# ENG-PUDSP21005-R1-PUDSP.pdf Markup Summary

**Subject:** Text Box  
**Page Index:** 1  
**Date:** 6/4/2021 10:12:08 AM  
**Author:** dsdparsons  
**Color:** ■  
**Layer:**  
**Space:**  
**Page Label:** [1] WB PLP amendment 3.10.21-Cover

SHEET TITLE: NORTHEAST AREA DEVELOPMENT PLAN

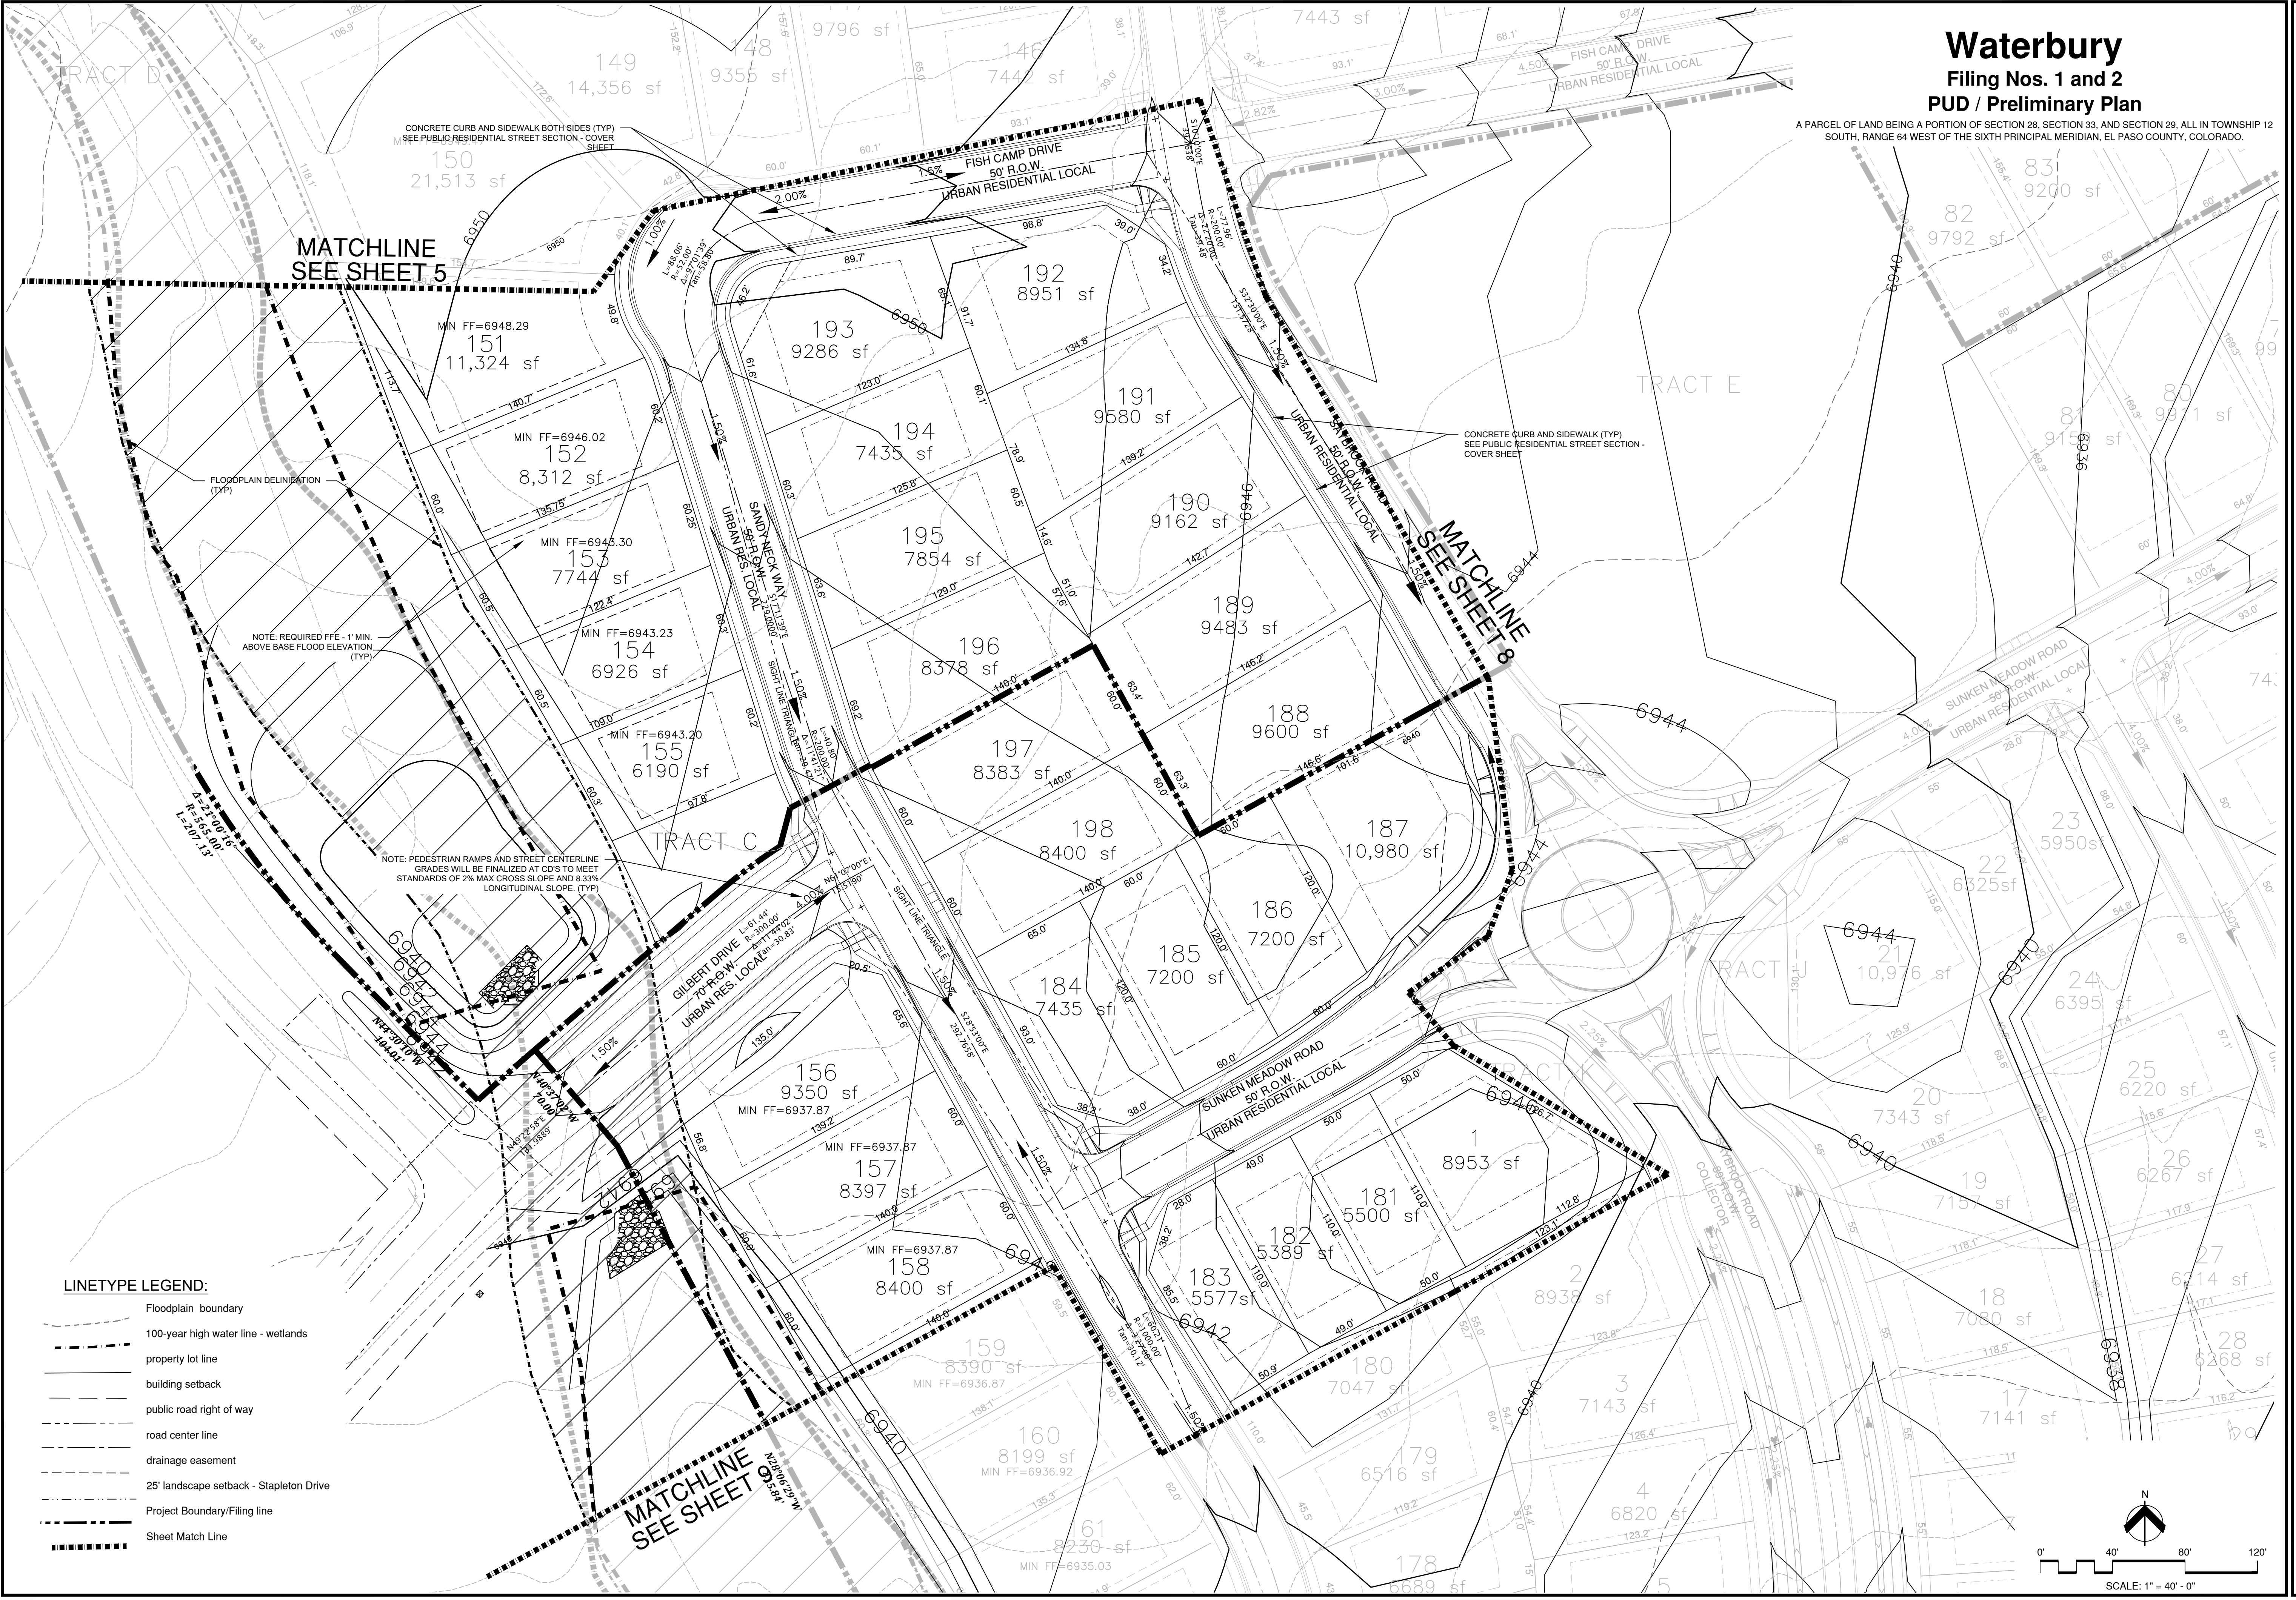
Drainage will need to be routed around the temp. cul-de-sac
